Preferred Project Report  
Site 8a, Sydney Olympic Park  
Major Project 06\_0175  
Prepared for Watpac Developments Pty Ltd  
February 2008

The Environmental Assessment Application for development of a commercial office building at Site 8a, Murray Rose Avenue, Sydney Olympic Park Homebush was placed on public exhibition for 31 days from 7 November to the 7 December 2007. During that time 5 submissions were received from public authorities including the Sydney Olympic Park Authority, Auburn Council, Sydney Water, RTA and the Heritage Office. In addition, the responsible authority, the Department of Planning also provided comment.

SCALE AT A2	DRAWN	CO-ORDINATED	CHECKED	APPROVED
1:1000	CW/EB	CW	SO	SO
JOB NO.	PSA 7515	DRAWING NUMBER	1100	REV
				B

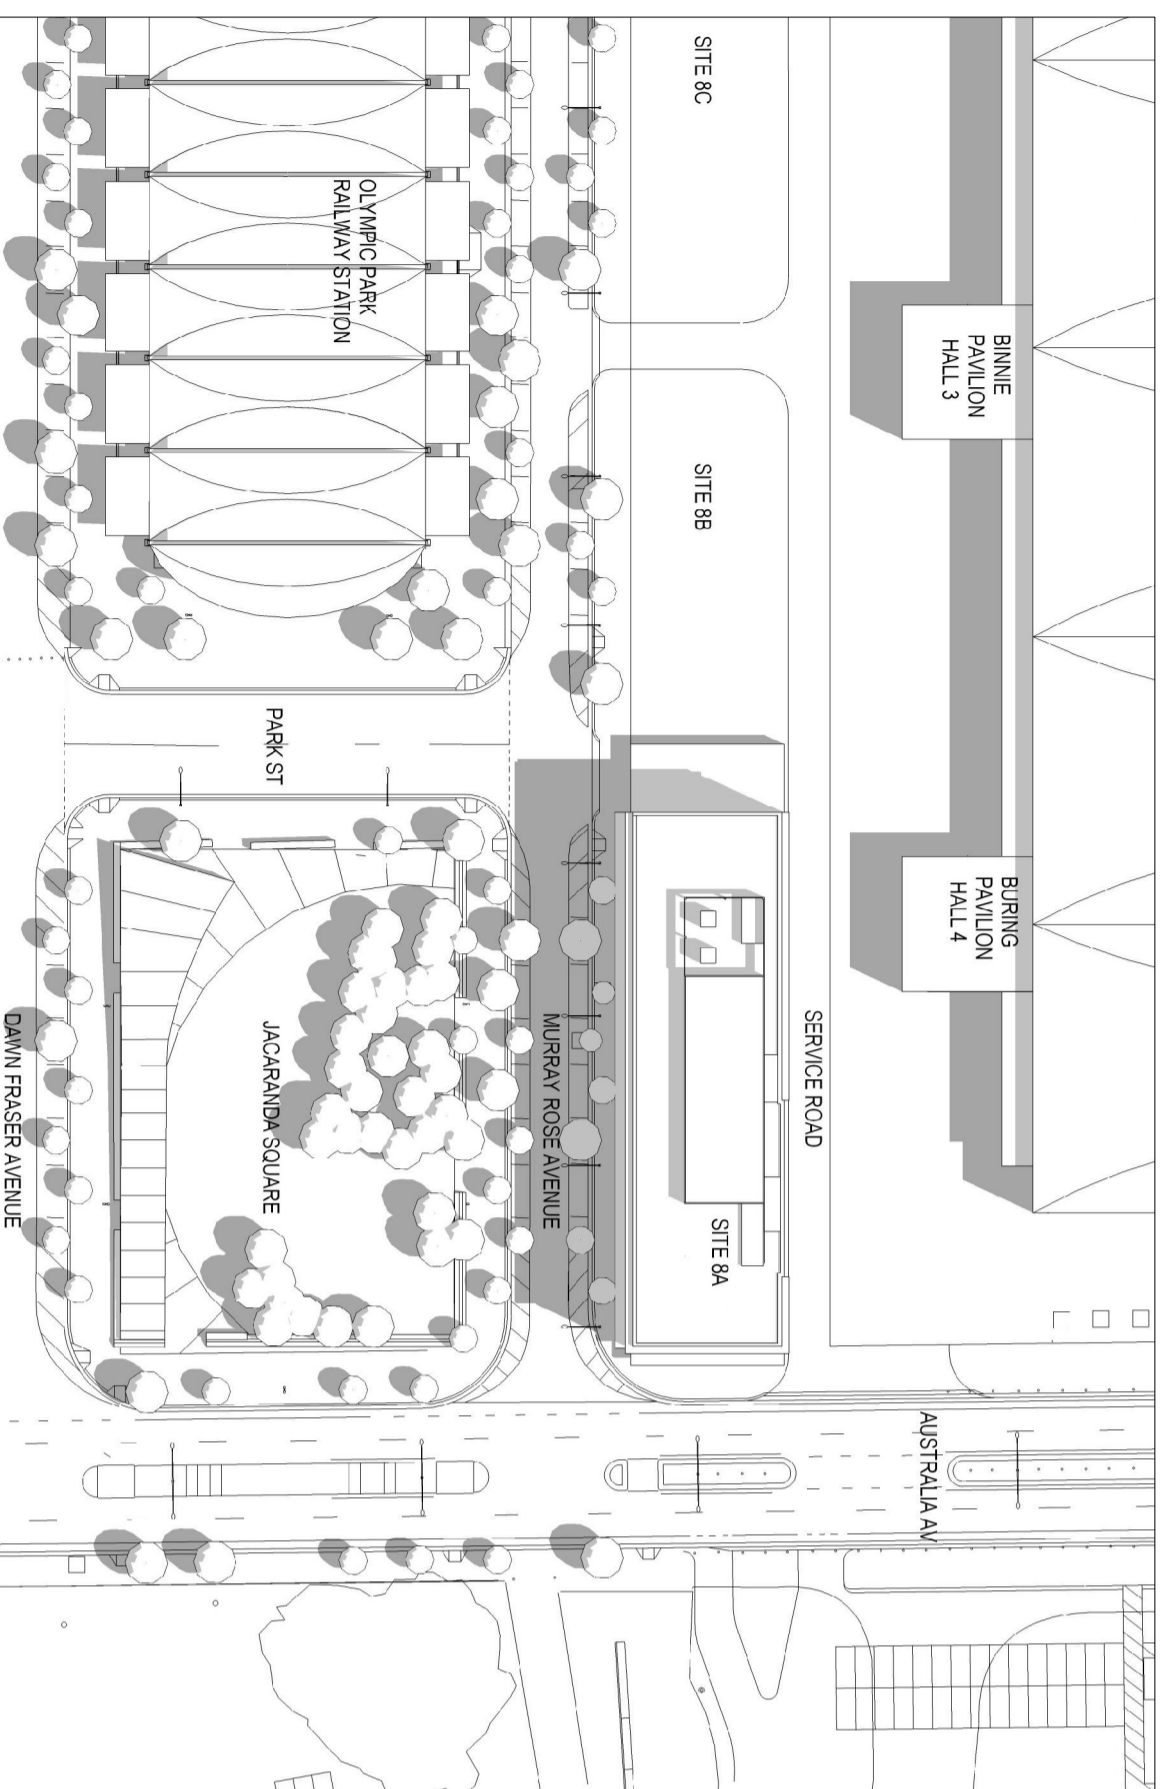
- 3.2.3 *The SOP Master Plan 2002 design guidelines (Section 6.1.1) state that 'solar access to important public spaces should be optimised between 11.30am and 2.30pm on June 21'. To determine the extent of the proposal's impact on Jacaranda Square, hourly shadow diagrams are required to be submitted between 12.00pm and 3.00pm on June 21. The shadow plans must clearly highlight the proposed buildings shadow, as separate to the shadows cast by the street trees.*

Drawing PSA7515-1104-A has been added with the additional shadow diagram on June 21 at 1 and 2pm. Drawings PSA 7515-1000, 1001, 1002 and 1003 have been revised to distinguish between building and tree shadows.

Figure 2.1: Proposed loading areas for Site 8a

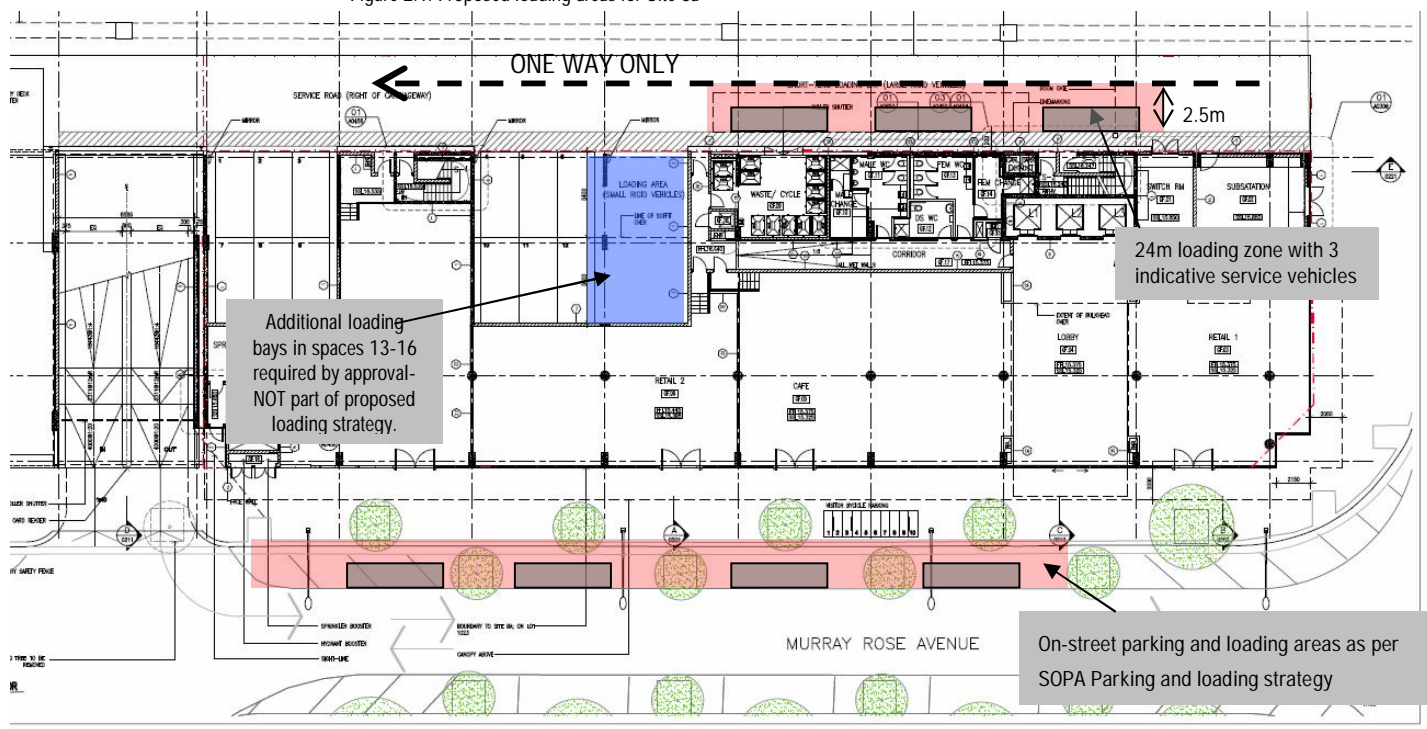
- 3.2.5 *A loading area suitable for accommodating LRV's needs to be provided within the proposed building footprint. The proposed loading area in the rear service road (R.O.W) is not acceptable given the future cumulative traffic impacts in this area, particularly when all remaining land parcels on Site 8 are developed.*

It is submitted that a loading area can be accommodated in the laneway through appropriate sign positing. The service lane is considered suitable for loading as the 6m carriage way provides for only single direction traffic and the traffic flow is restricted to cars accessing the 16 at grade parking spaces and service vehicles. For further information please refer to Section 3.1.4.

Figure 2.2: Proposed roof plan for Site 8a

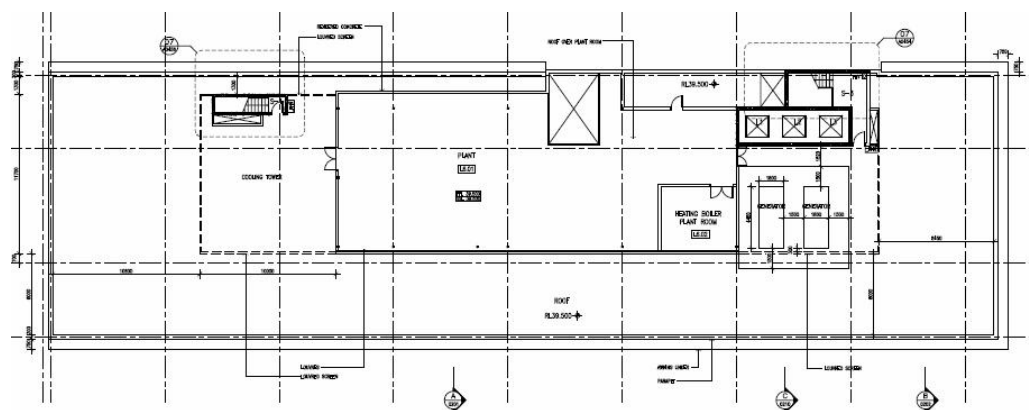
#### 3.2.12 Clarify the intended use and need for a future generator area on the rooftop and why it can not be accommodated in the nominated plant areas which are extensive.

An area measuring 6m by 14m has been reserved on the roof plant for a back up generator plant. The generator plant will only be installed on the roof to provide back up electricity on a temporary basis when required. The space provision for the tenant generator is required for classification as an A-grade office building under the Property Council of Australia.

The back up generator plant has been located in its current position as there is limited space in the main plant areas. As demonstrated in a draft detailed design plan for the plant area below, ducts will be connected between the risers and the air handling units, which significantly reduces the amount of space available on the plant.
